2025/0093

31, Manor Court, Churchfield Lane, Kexbrough, S75 5DH

Change of use of part of the building (formerly a care home) to a 13 bed HMO.

**PROPOSED GROUND
FLOOR LAYOUT**
SCALE 1:100

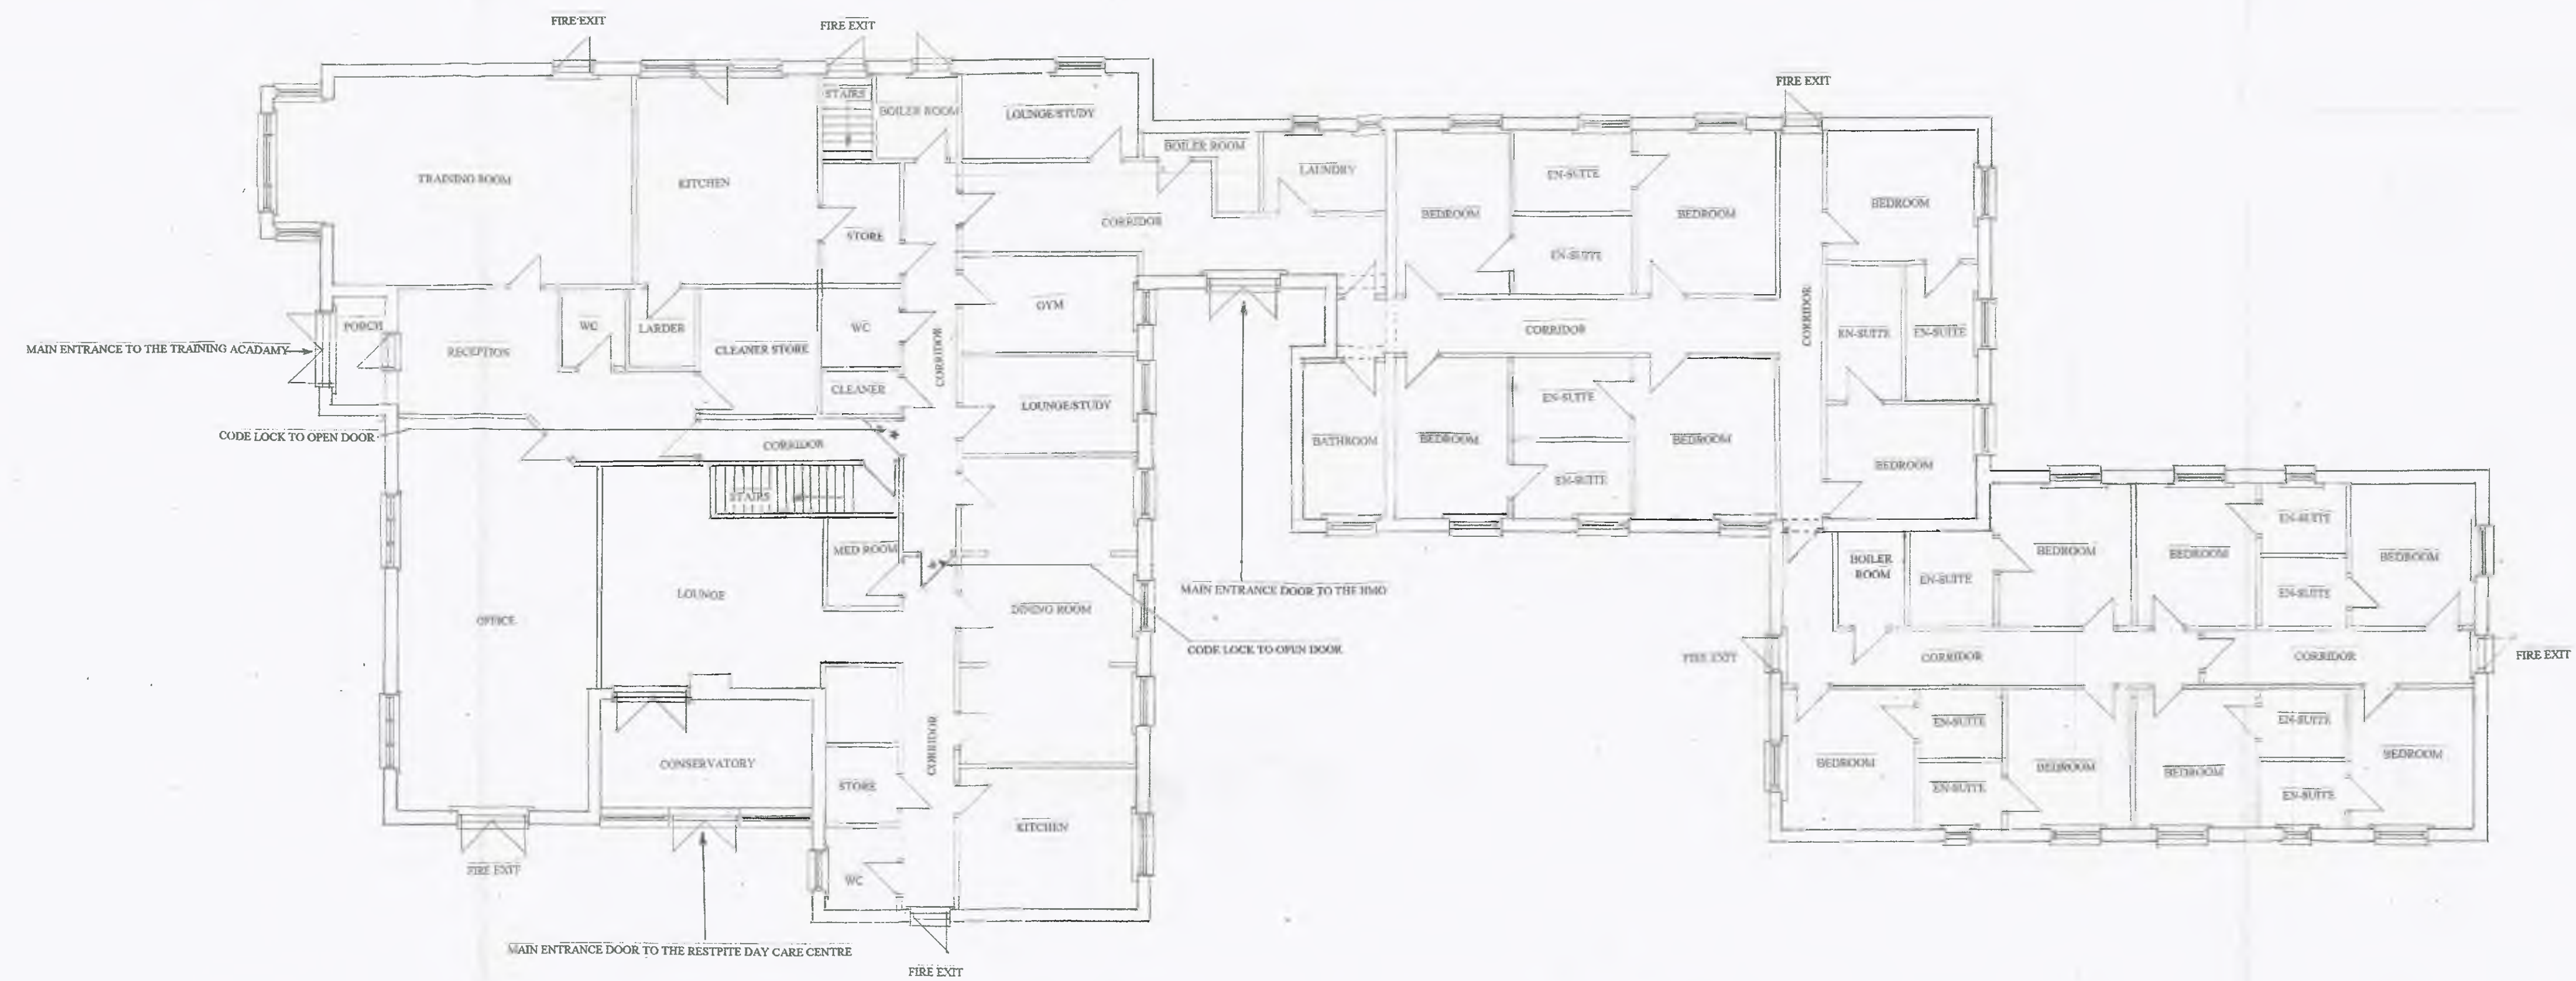
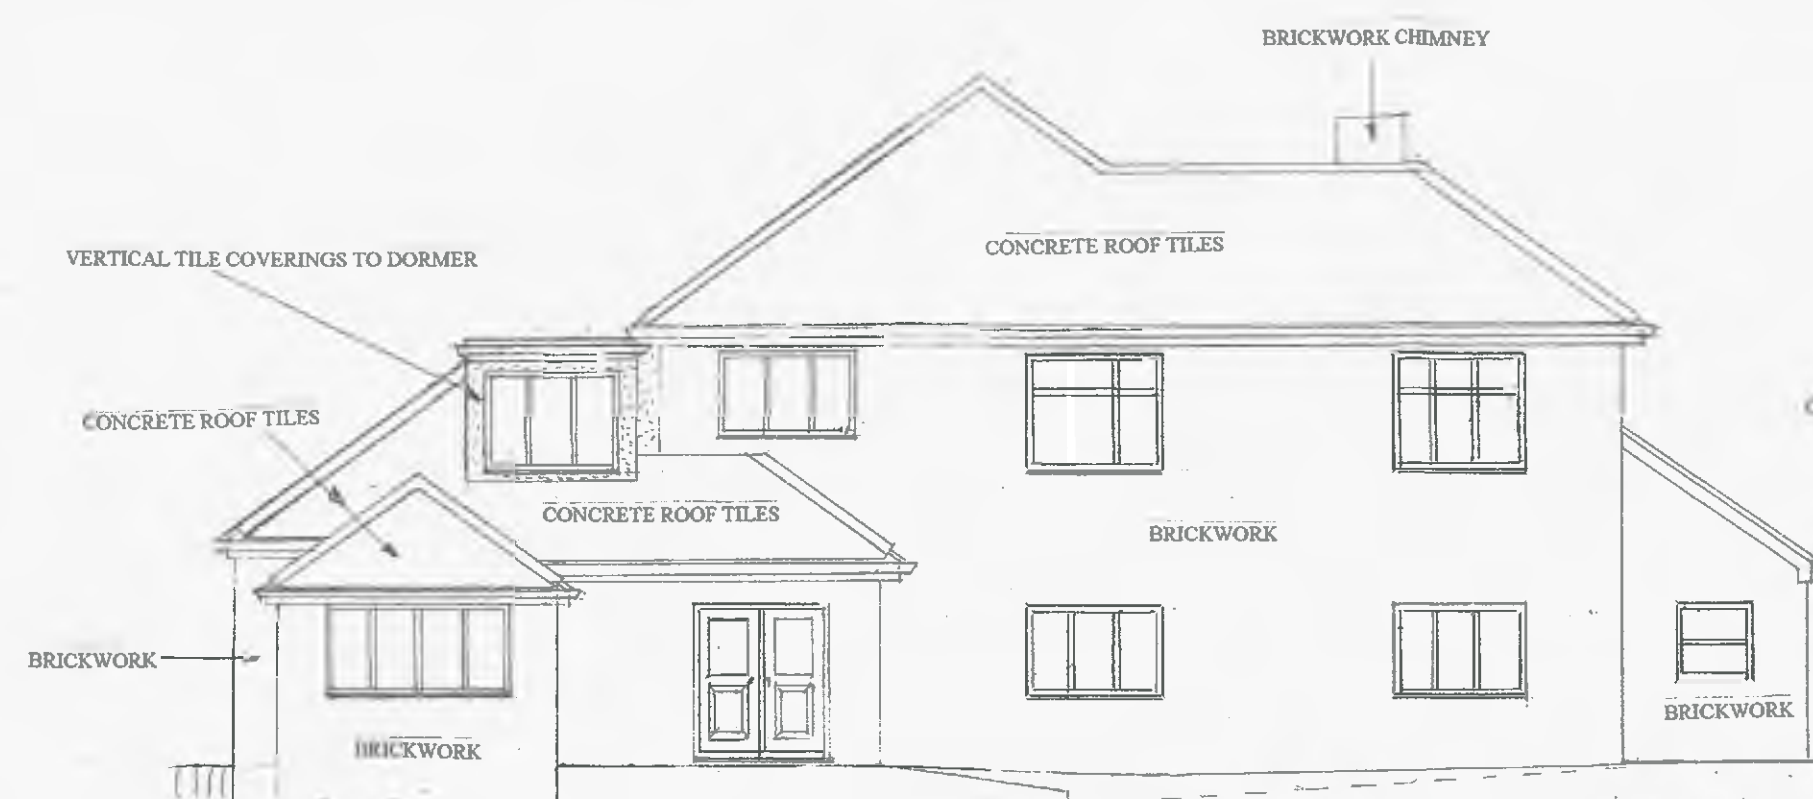
The Case Management Officer has provided comments and states that given the size of the HMO there is a requirement to provide two separate kitchen areas. At present the floor plans indicate only one kitchen and amendments would be required before the Case Management Officer could support this application.

In terms of design, the internal layout shows one single large kitchen with an attached Larder room. It also indicates there would be two separate dining rooms and three separate rooms for dining/living. The Case Management Officer has noted that due to the property being classed as a 'large' HMO two separate kitchens would be required and internal alterations would be required to provide the appropriate facilities.
